Thorpe on the Hill Parish Council - Interested Party Ref: [REDACTED]

Notes from OFH1 Oral Submission

Fosse Green Energy (FGE) – Deadline 3

Site Access Location Plan

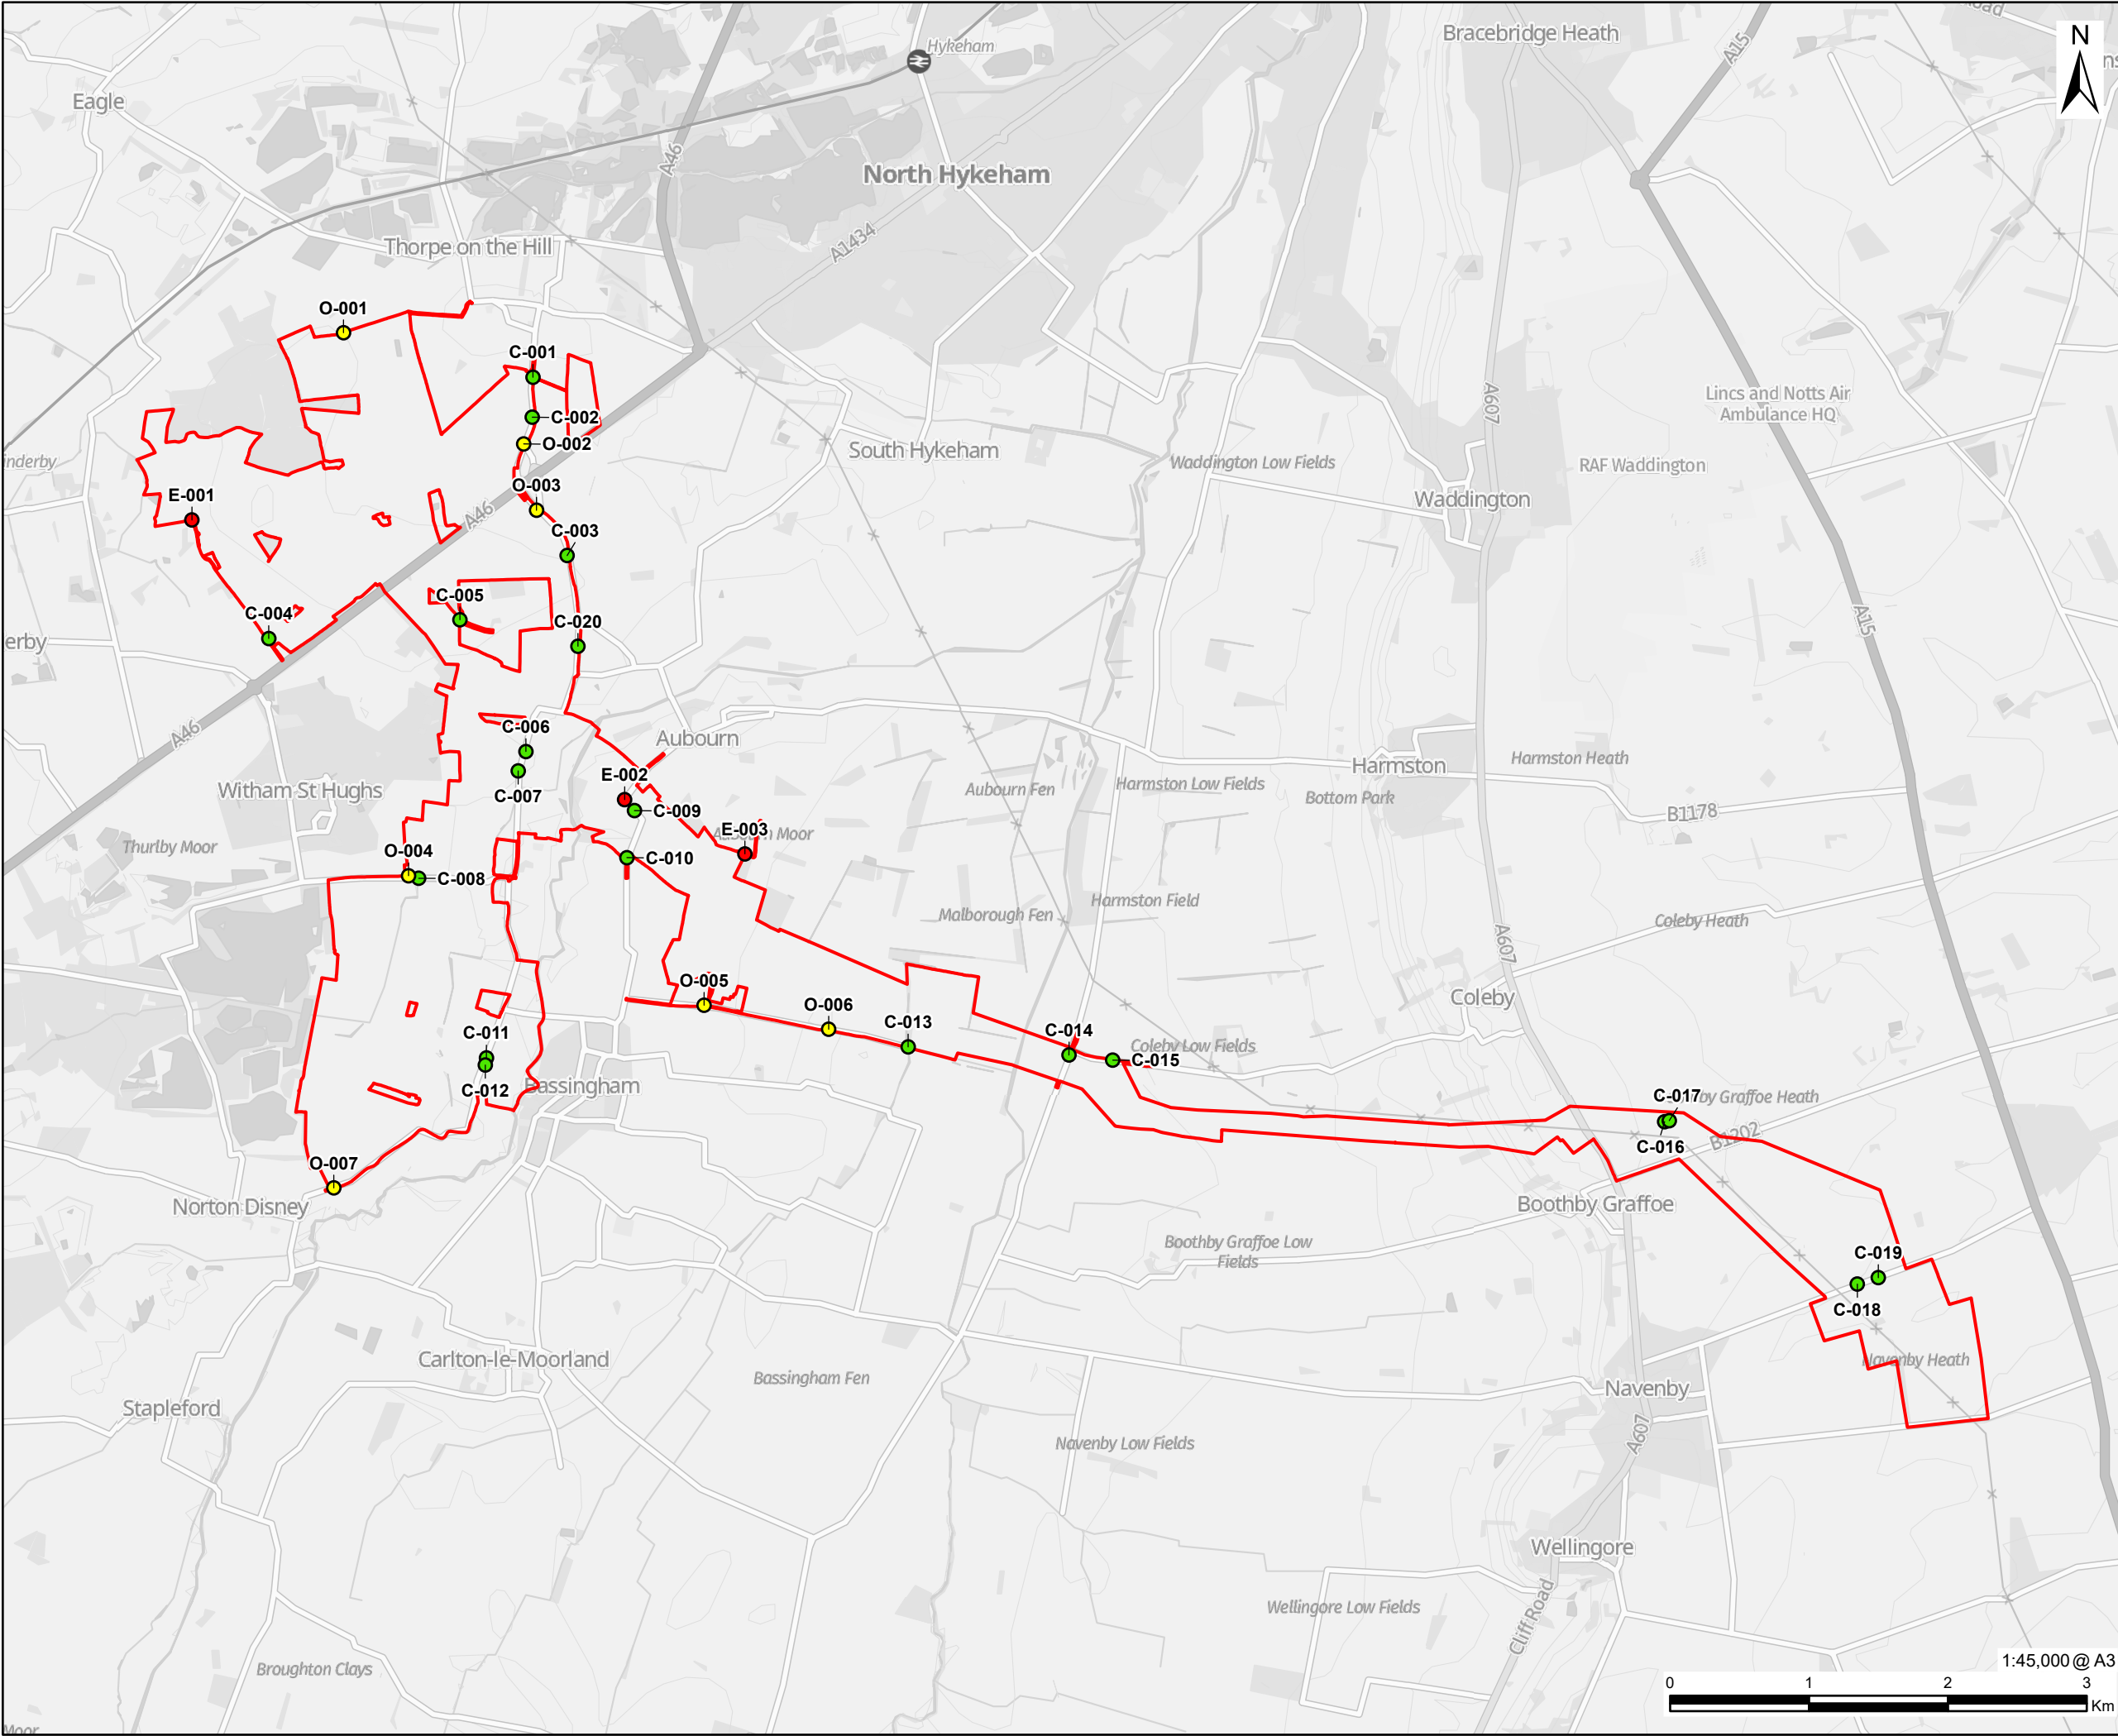
These additional HGV movements have only recently emerged and therefore were probably outside the modelling for the FGE scheme and worst-case scenarios. Additionally, the entrance to the Feedstock Storage Facility is directly opposite Construction and access point C-003. Field 4/16 from Land Plans APP-007.

The fact that these two site entrances lie opposite one another close to the brow of a hill on a de-restricted road presents a significant risk of accidents and should be reviewed carefully.
